## Application for a Non-Material Amendment Following a Grant of Planning Permission

Erection of single storey rear extension, solar pv panels to front and rear, removal of pier between garage doors and new front door to enclose entrance porch

49777/APP/2022/3851

The proposal is rearrange the layout of the PV panels on both the front and the rear of the roof from a two across three down arrangement to a single file of six across the roof, both front and rear

DRG TITLE
PROPOSED ELEVATIONS

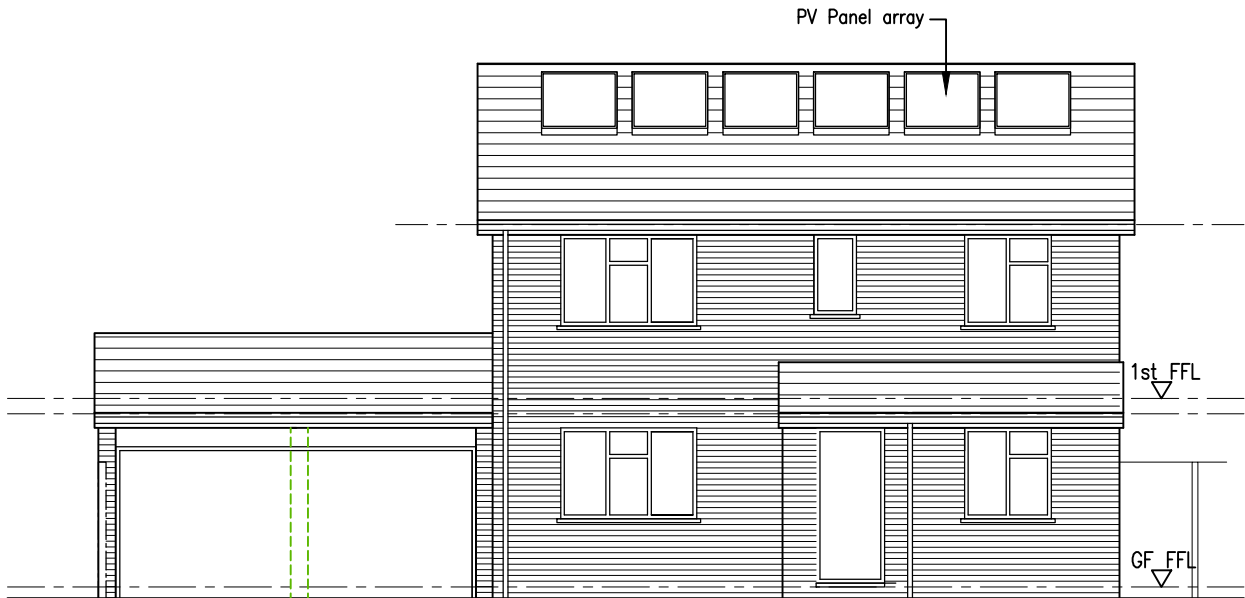
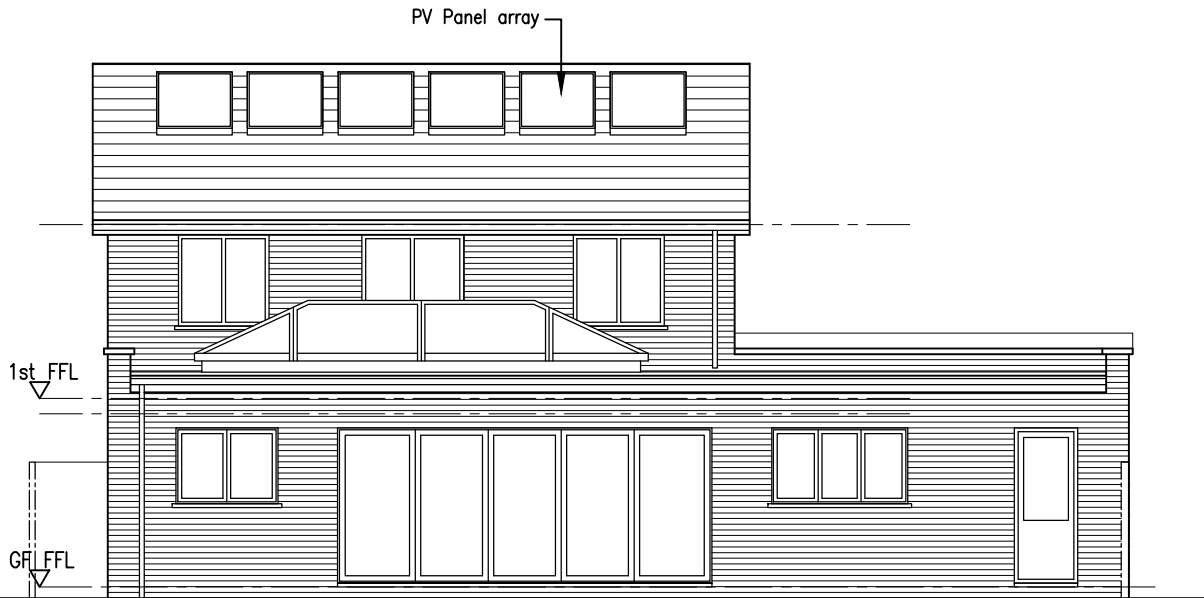
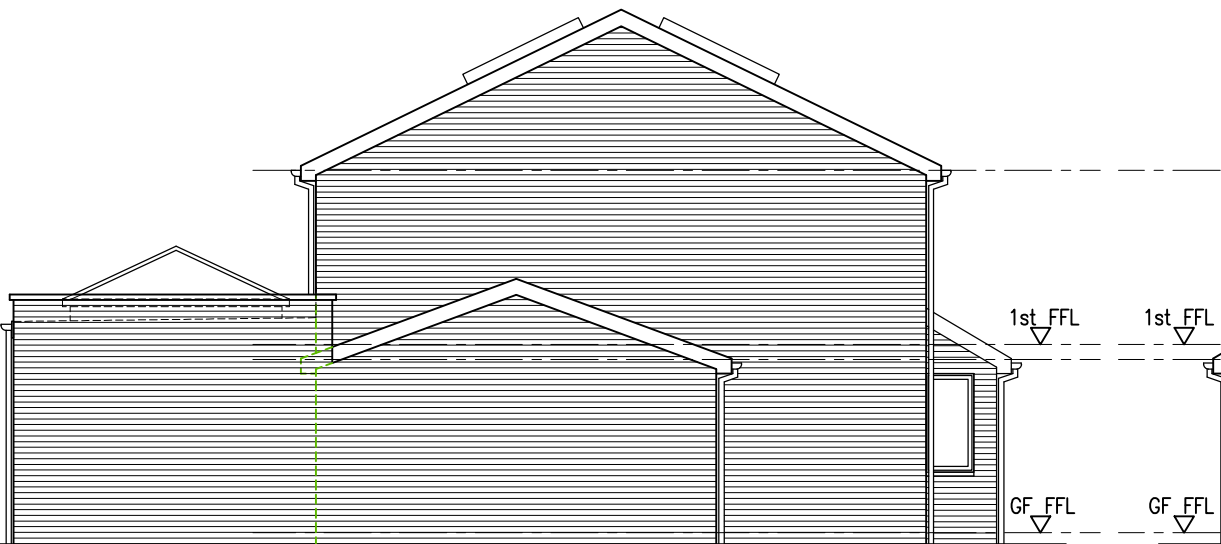
Upon the recommendation of the PV panel manufacturer, taking into account the loading on the roof.
